Project #1006009 Mesa del Sol Tract 24  
13DRB-70731 – Vacation of Private Easement

DRB CASE NO: 1006009

**DRB PROJECT NO: 1006009**

**PLAT OF
TRACTS 24-A & 24-B
MESA DEL SOL
INNOVATION PARK**

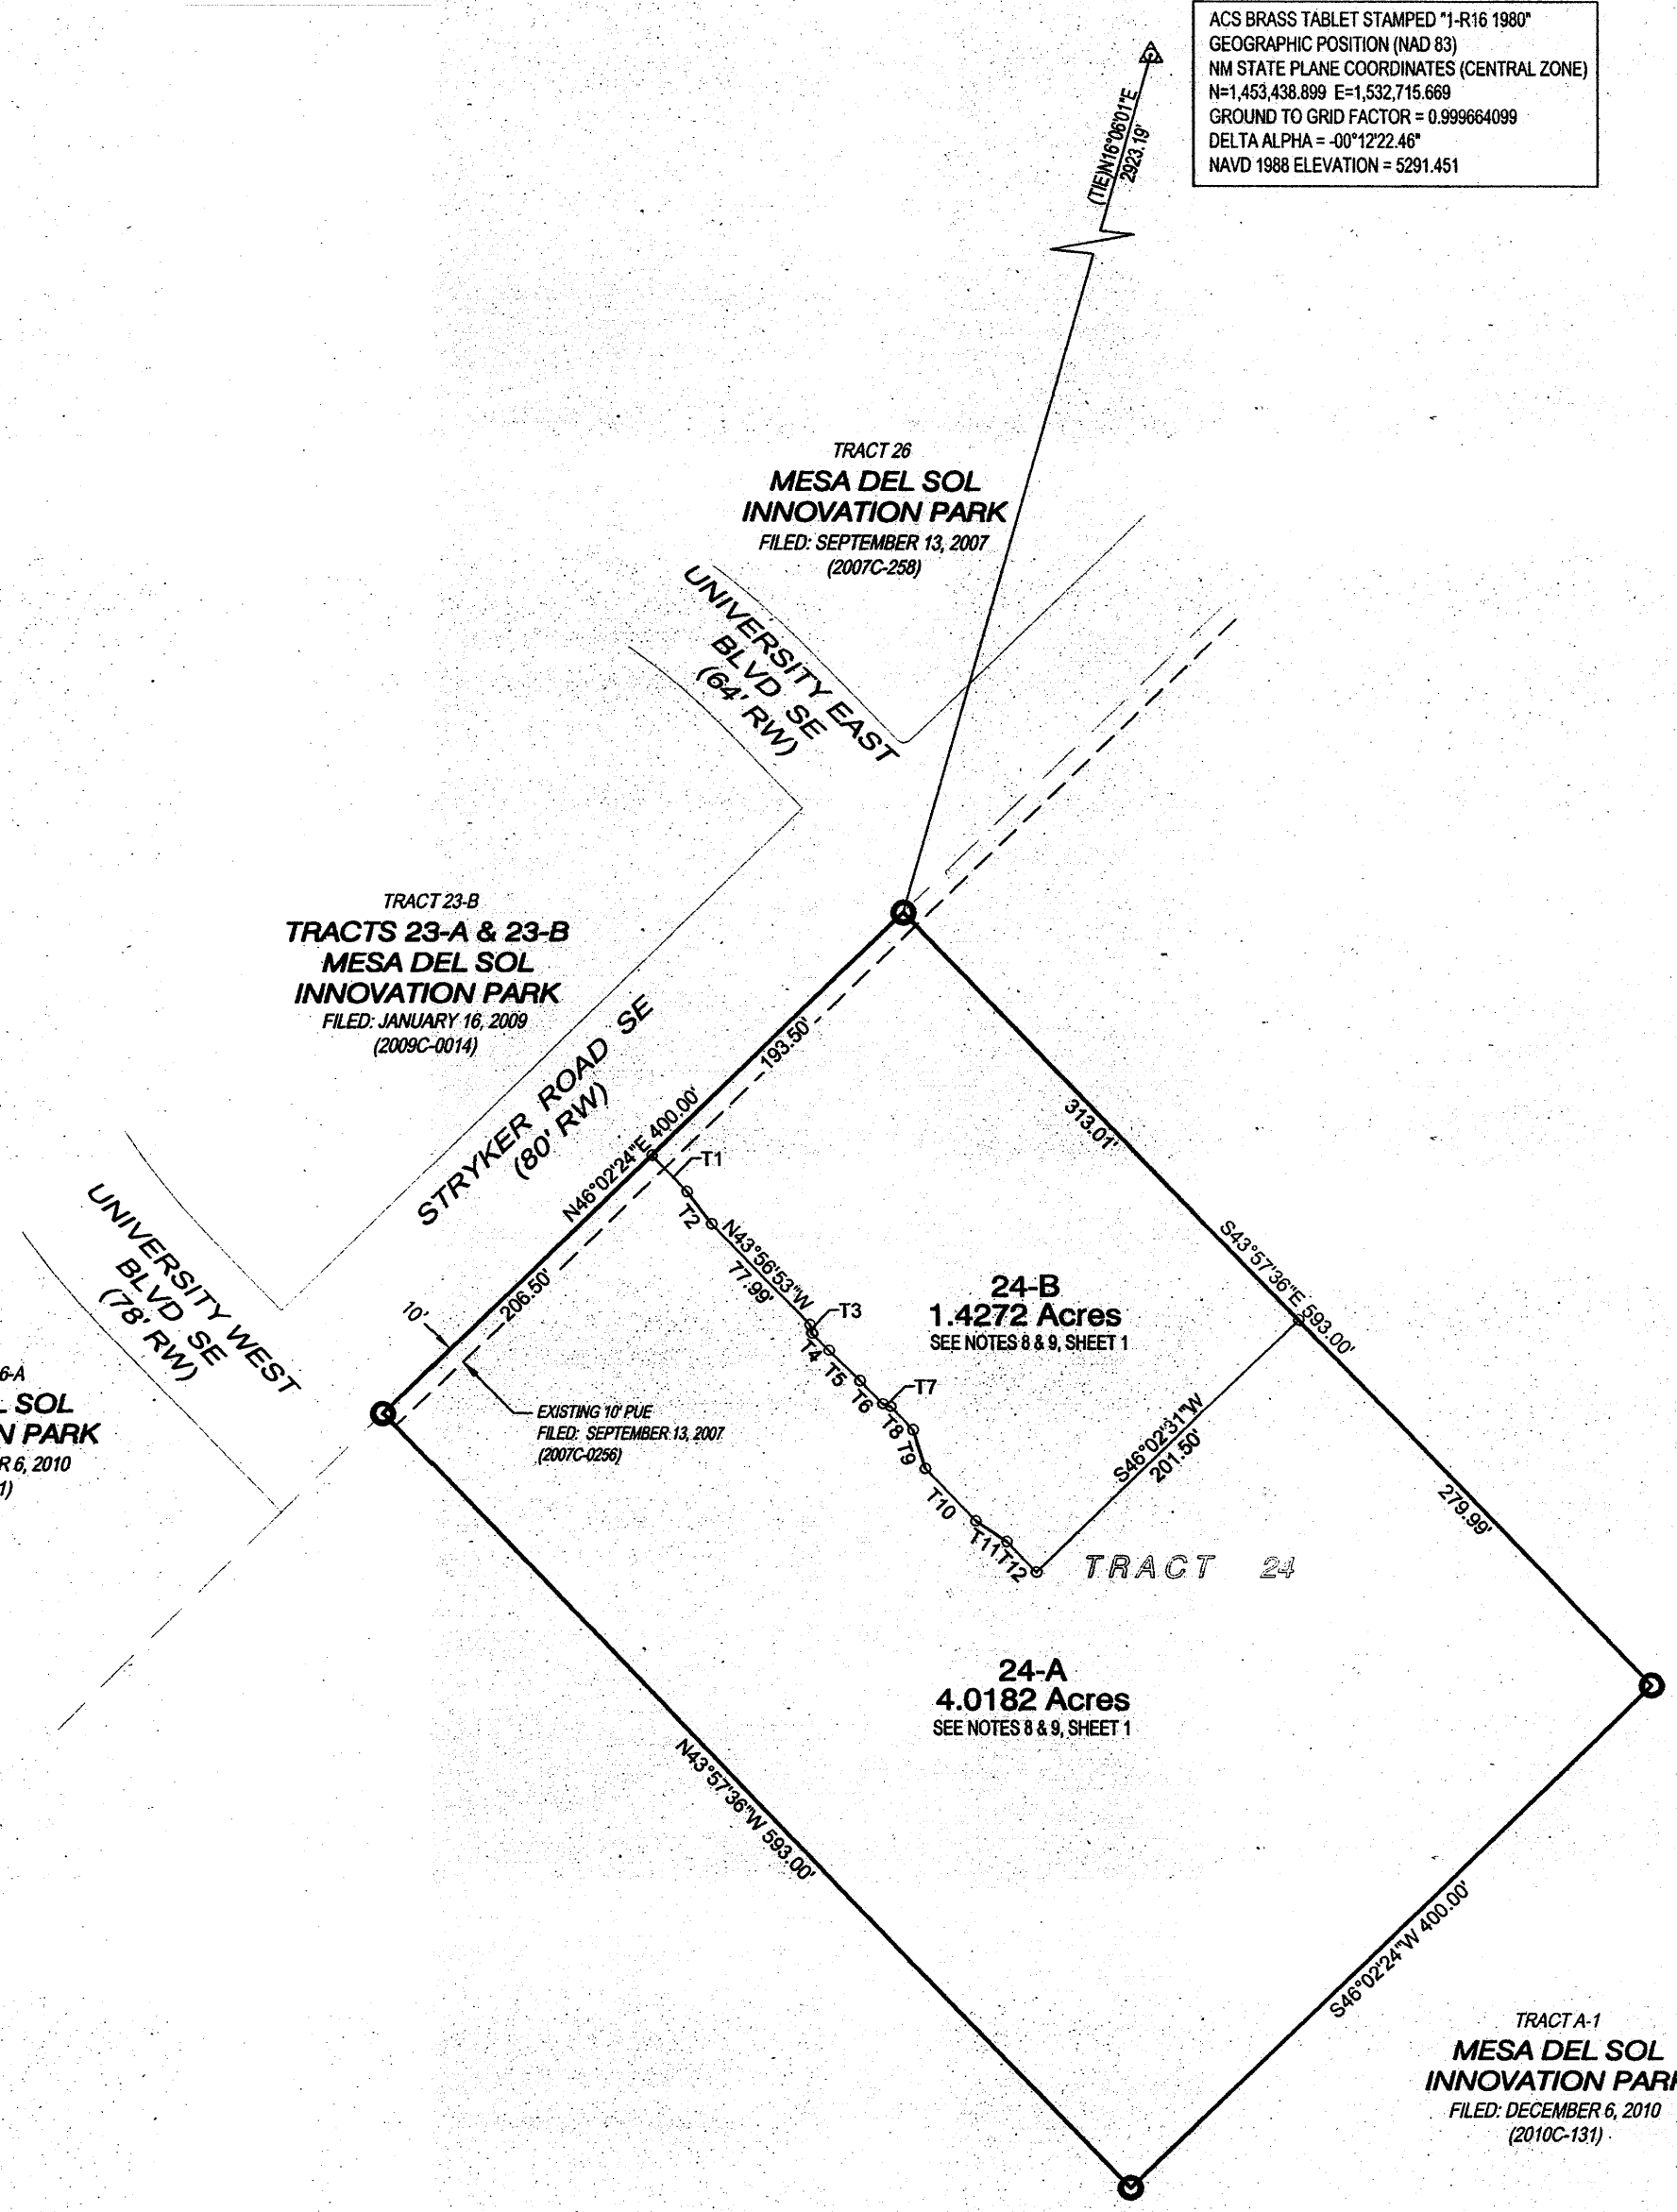
Provide an exhibit showing the location of sidewalk and defining the distance from back of curb to the property line. Right of way dedication may be required.  
Clarify existing conditions. Infrastructure and right of way dedication is required. Please refer to the master plans for this area for the proposed street layout.

An infrastructure list is required for half a street section on West University Blvd, East University Blvd, Scorcese Ave and North Mesa Del Sol Blvd.

ROW dedication is required for Scorcese Ave and North Mesa Del Sol Blvd.

Hydrology has an informational drainage report from 2007. This report should be revised to determine drainage infrastructure requirements. The "Road pond", URS April 2011 should be addressed in this report.
